20 January 2026

**Panorama Battery Energy Storage System (SSD-50587460) – DPHI Requests for Information
July 2025**

Figure 1 Site Location and Surrounding Receivers

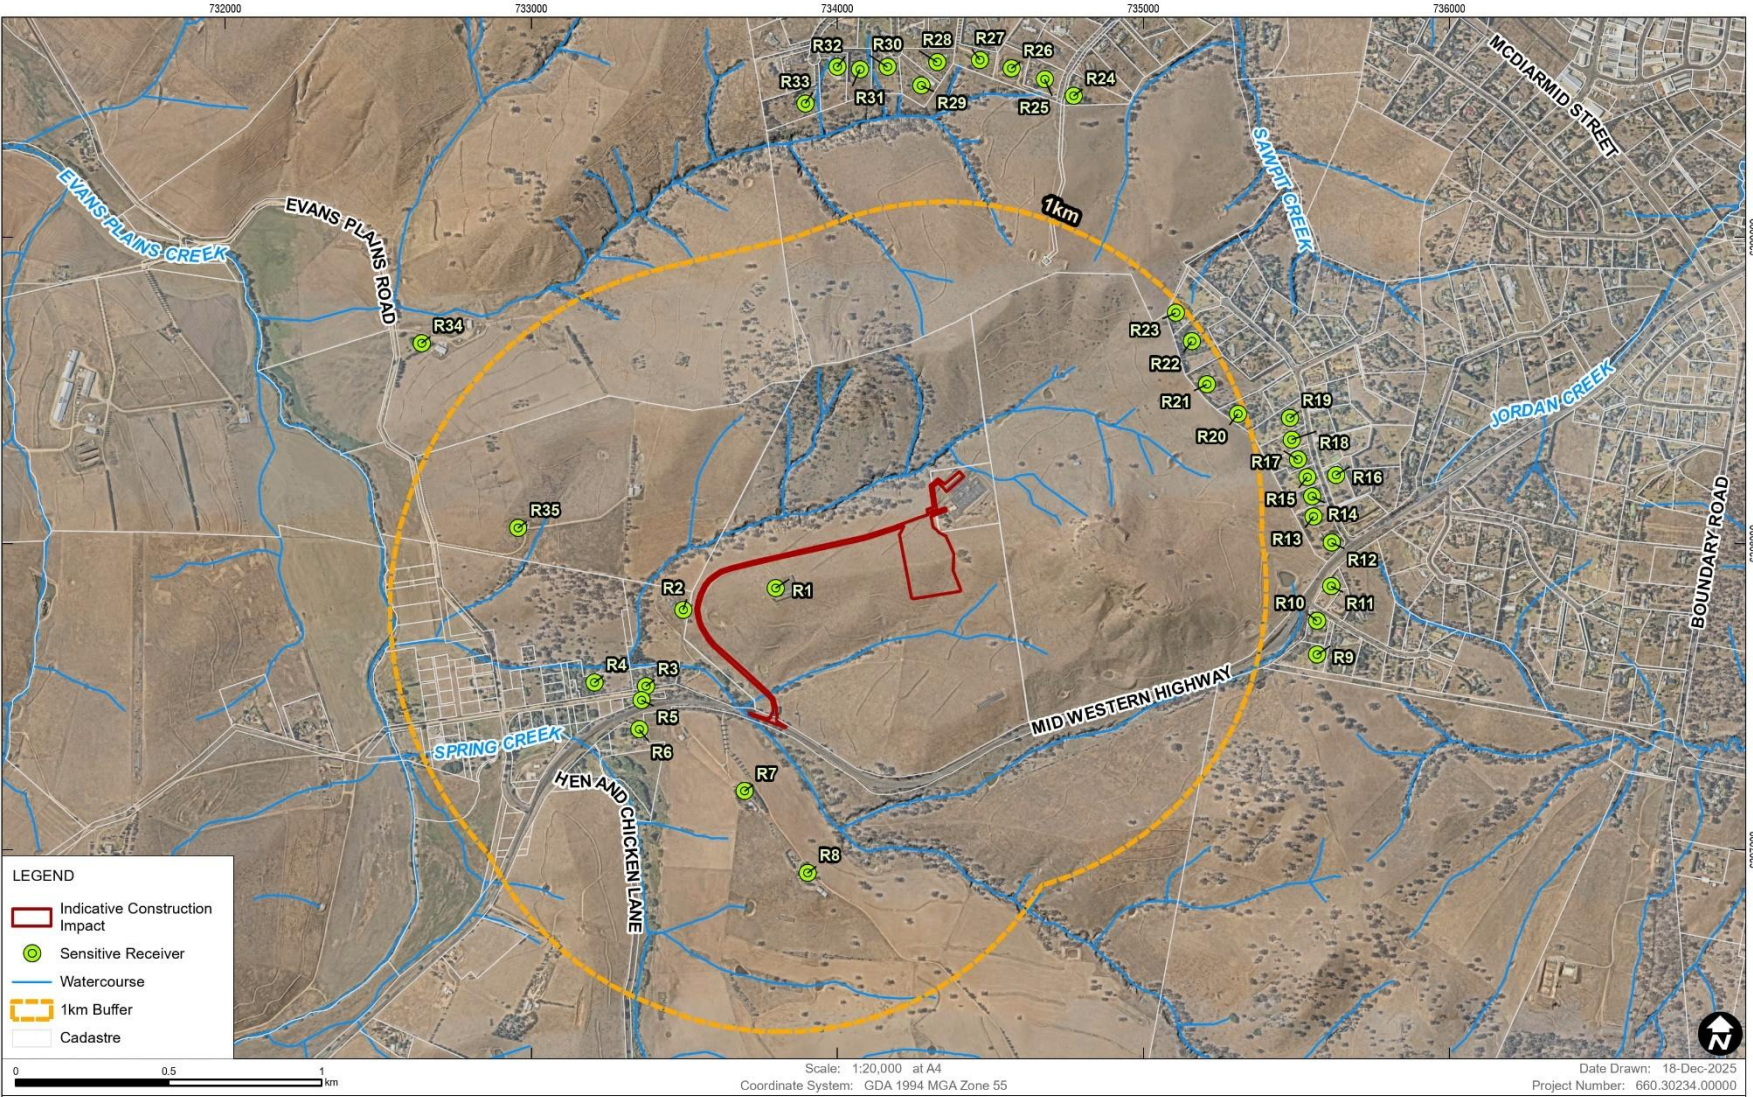
Section 3.2 of the Amended NVIA (page 17/94) states the nearest residential dwellings are located on Denison Street and approximately 150m to the east. Please clarify the location of the nearest residential dwelling and update the Amended NVIA if required.	The Noise Impact Assessment (NIA) has been updated by SLR (v3.1 January 2026) – included as Attachment 1. Section 3.2.2 (page 16) of the NIA has been amended to clarify the location of the nearest residential dwellings, including: 800 Mid-Western Hwy, Evans Plains (490 m to the east of the BESS)
